Application by RWE Renewables UK Solar and Storage Limited for an Order Granting Development Consent for the Byers Gill Solar Project. PINS Reference No: EN010139.

The Examining Authority invited all Interested Parties to submit 'Comments on responses to ExQ1 by Deadline 3 by Thursday 19th September 2024 .

Bishopton Villages Action Group Comments on Applicant's Responses to ExA Q1

Drawing Title  
Panel Area A  
Vehicle Access - Aycliffe Lane/  
Brafferton Lane/ The Green  
Sheet 1 of 9

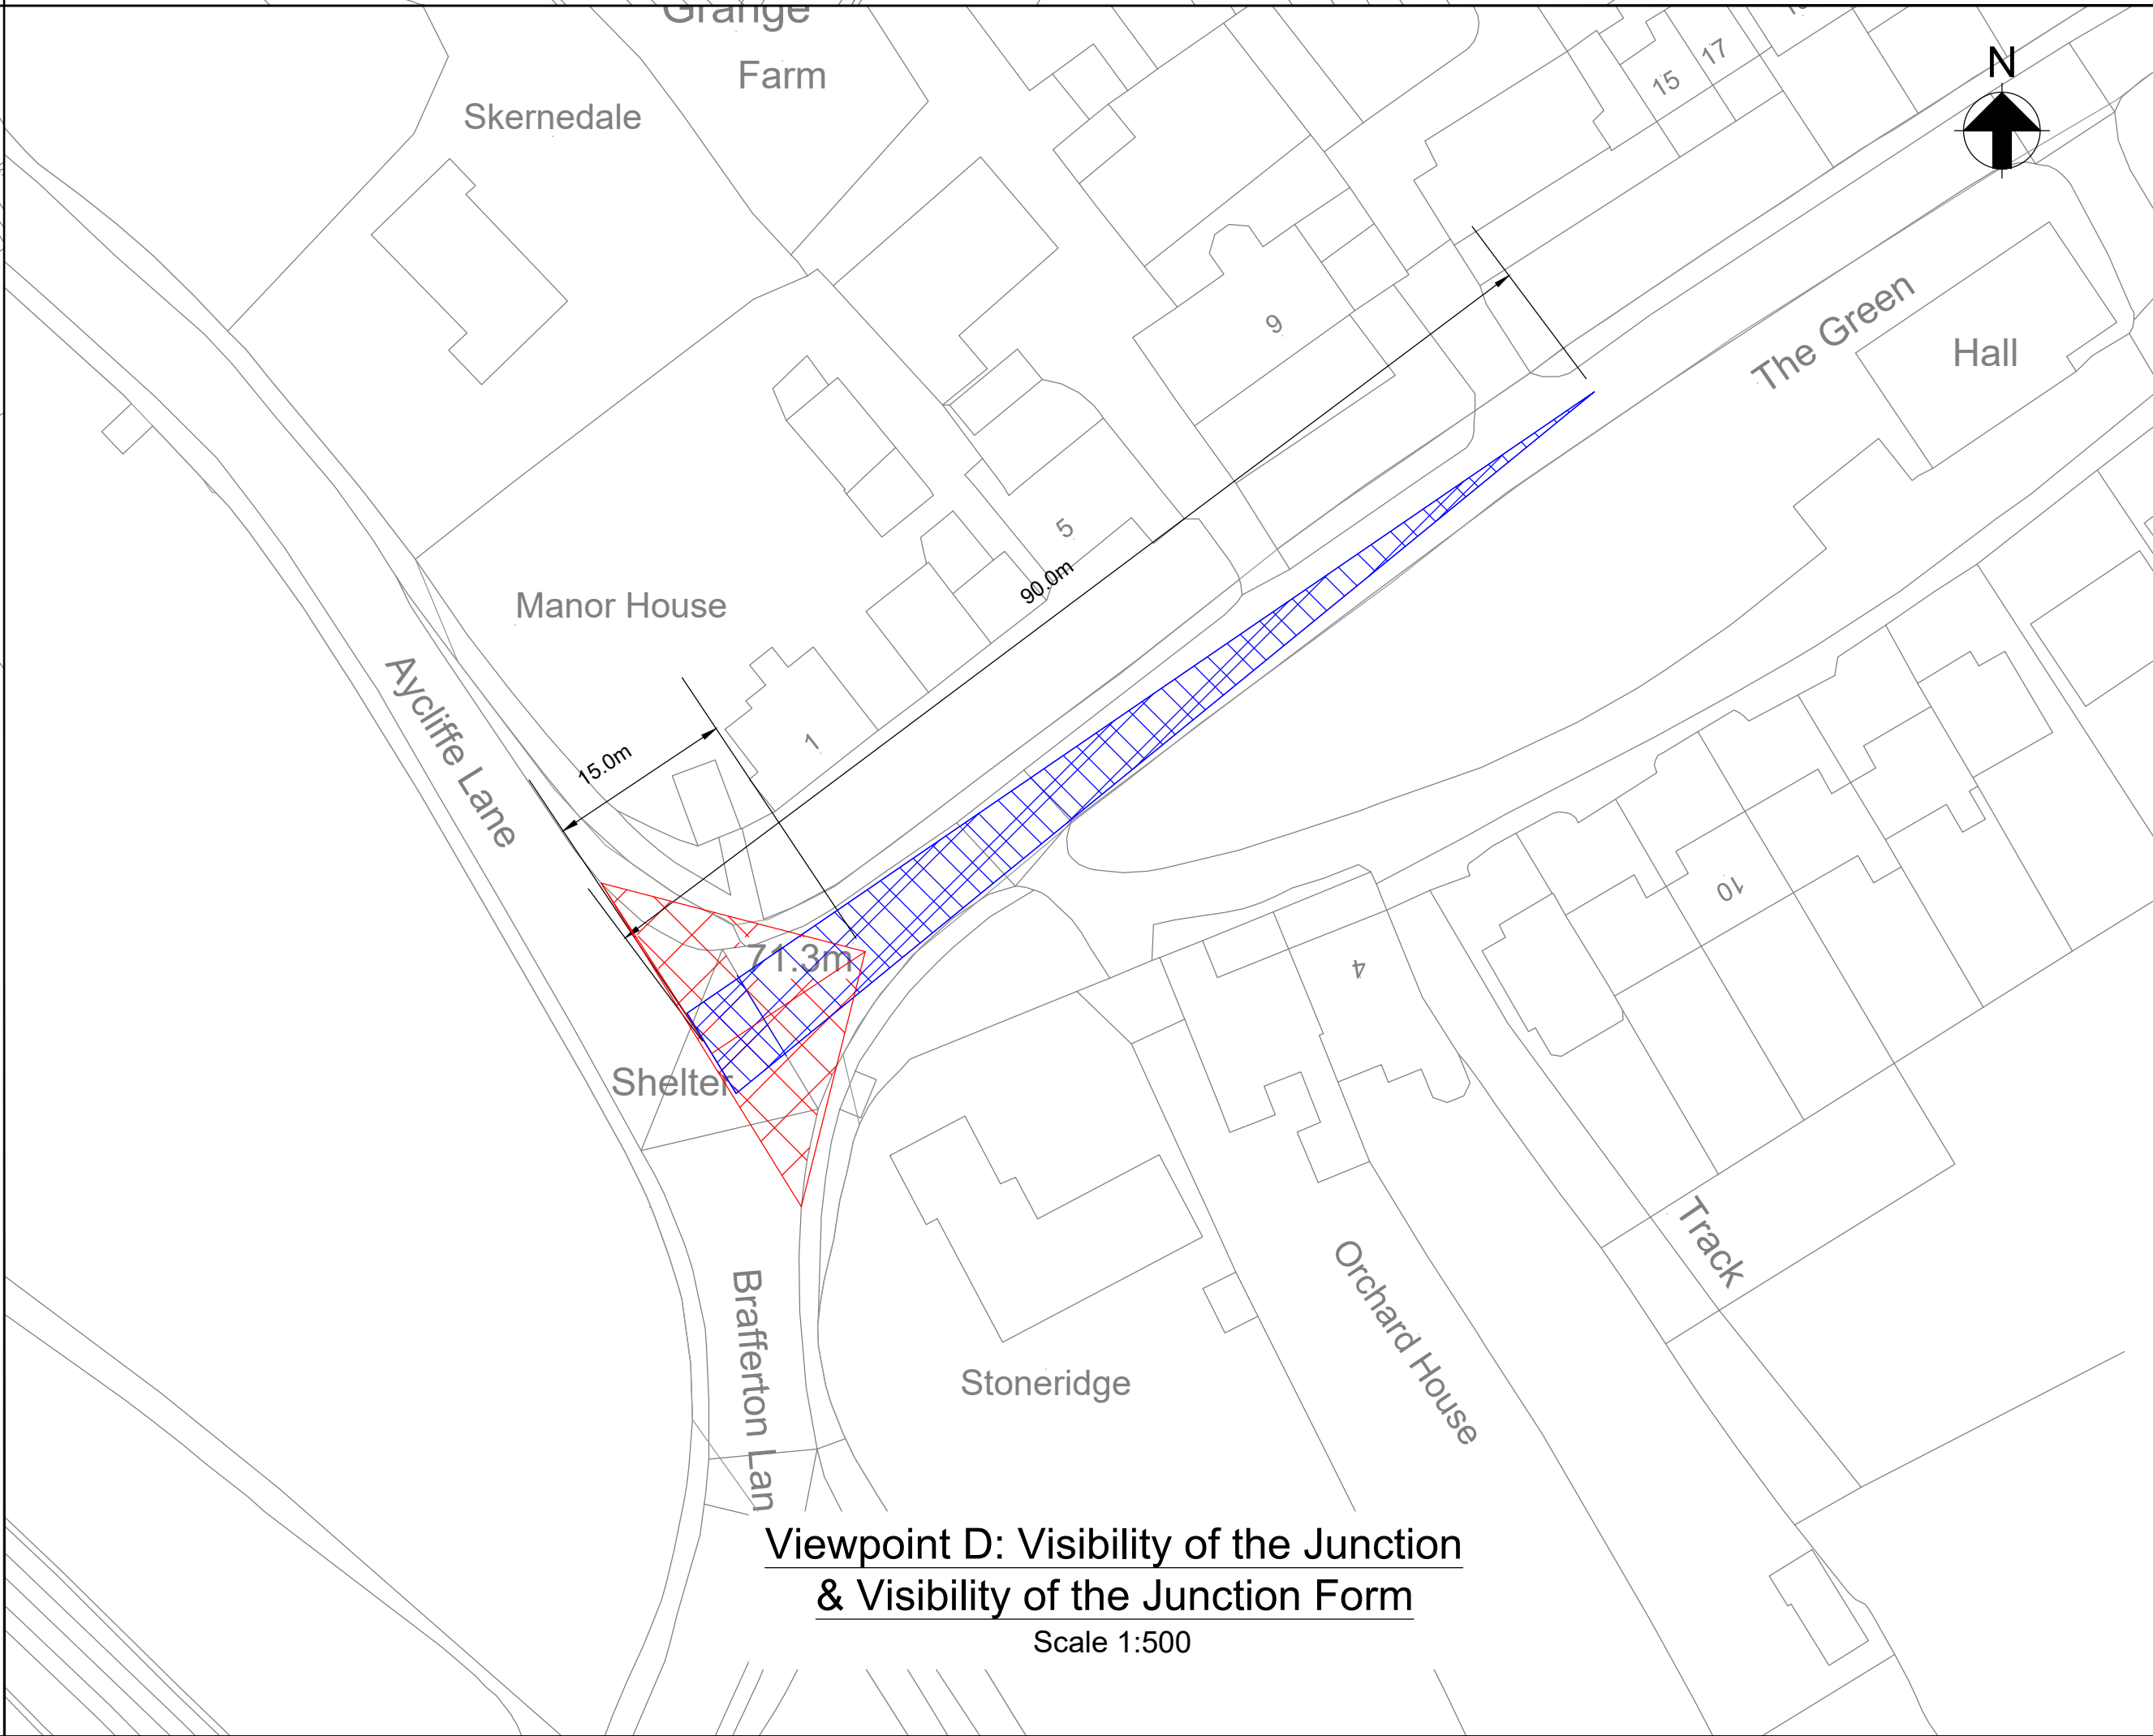
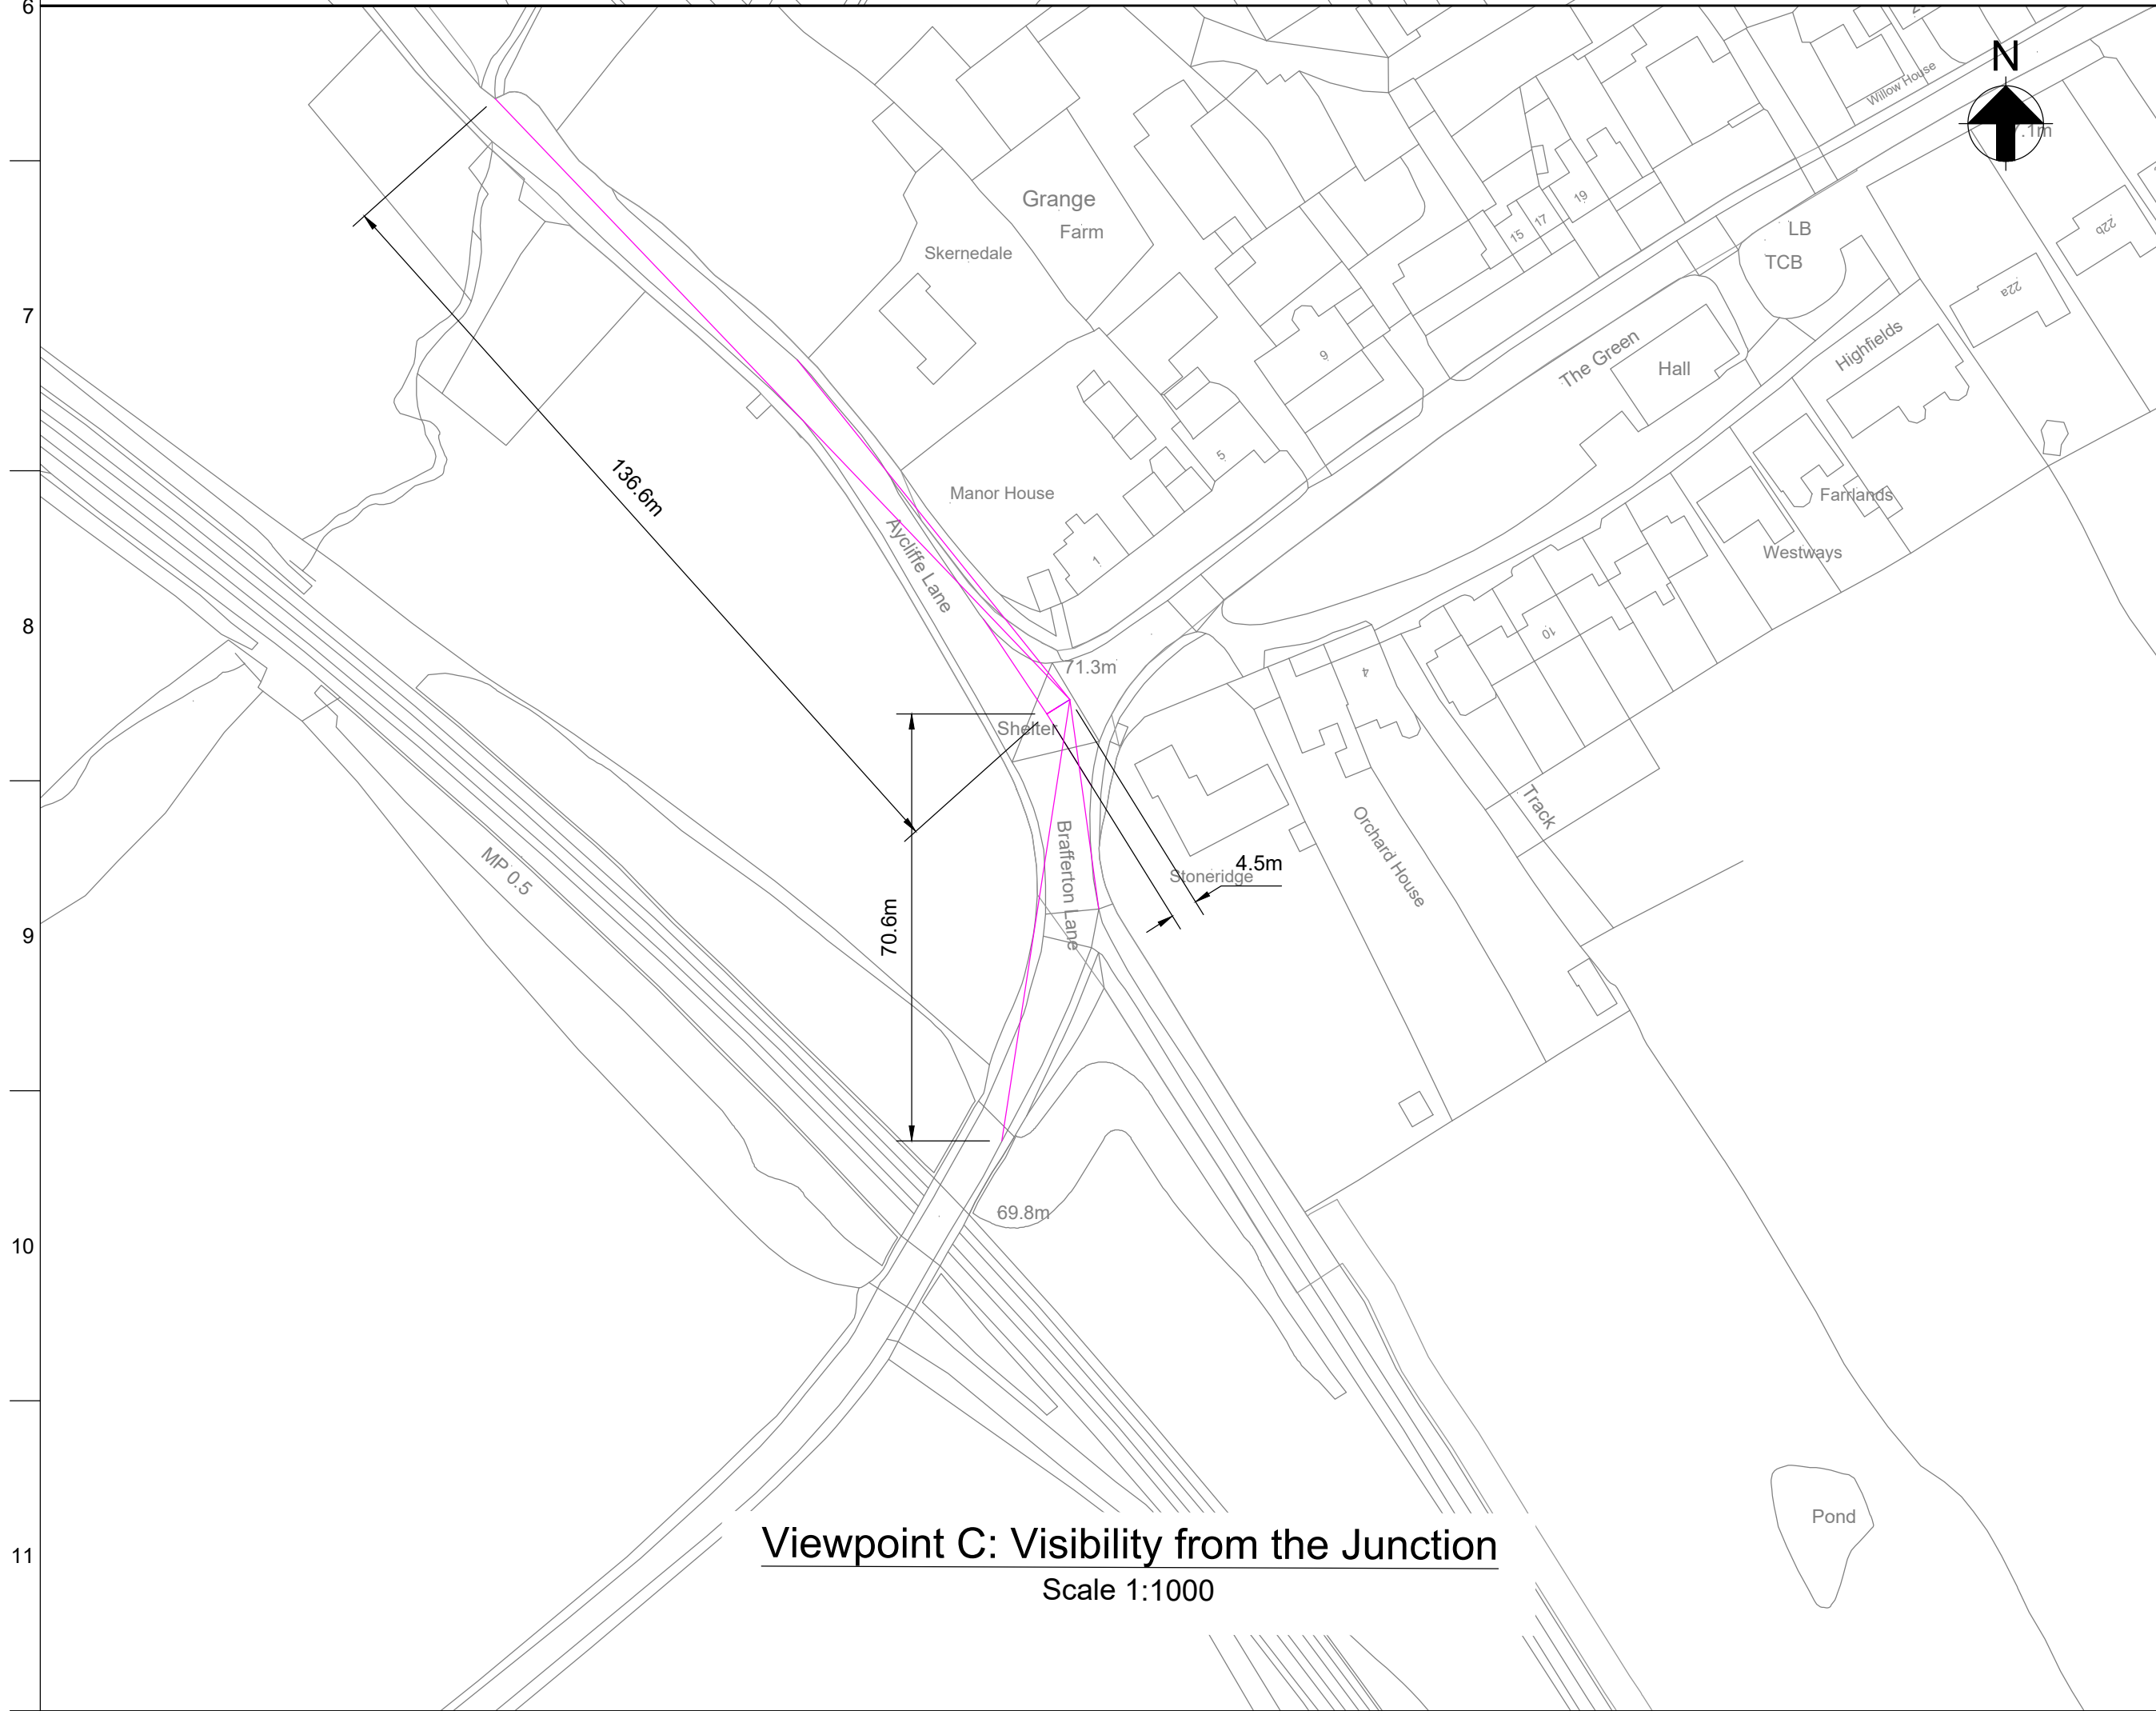
TT.1.23	Re existing access point to the southern section of Panel Area A	<i>The Outline CTMP [APP-112] highlight[s] that use of the access will need further consideration by</i>	BVAG is very concerned about the various significant adverse effects likely to arise from

<i>the Principal Contractor, when appointed, to ensure it can operate safely.</i>	<p>proposed access to the site, but specifically, access to Area A south and north.</p> <p>Insufficient survey, analysis and assessment has been carried out to establish whether access to Area A is feasible as proposed, or at least, without giving rise to extensive and permanent adverse effects on landscape, views, biodiversity as a minimum. See doc. REP2-044 paras. 4.2.2 - 37.</p> <p>These matters need to be addressed during the Examination, not when a contractor is appointed.</p>
TT.1.24	As above	As above	As above
TT.1.33	<p>Re Applicant's claim that <i>due to a negligible increase in traffic on the LRN, the impact on pedestrian, horse riding and cyclist amenity will not be material, and, if at all, only in isolated locations.</i></p>	<p>The Applicant concludes <i>that there is expected to be a low level of impact from construction traffic on the amenity of pedestrians, horse riders and cyclists, and that the effect is not significant.</i></p>	<p>BVAG is very concerned about the various significant adverse effects on these and other receptors likely to arise from construction traffic at several locations. See for example doc. REP2-044 paras. 4.2.2 - 37. , and regarding horses specifically, paras. 4.8.2 ii), and 6.64.</p> <p>BVAG are very concerned about the lack of a commitment by RWE and their contractors to repair the damage to public highways which will result from construction works and would be liable for funding for repairs to Darlington Borough Council (i.e. local taxpayers). No mention is made of a commitment to repair damage in the CTMP.</p> <p>N:B: The ExA are encouraged to drive by the Whitfield Solar project to see an example of the damaged caused to the public highway by solar construction traffic. It would need only 5-10 mins to cover the route from already suggested itinerary.</p>
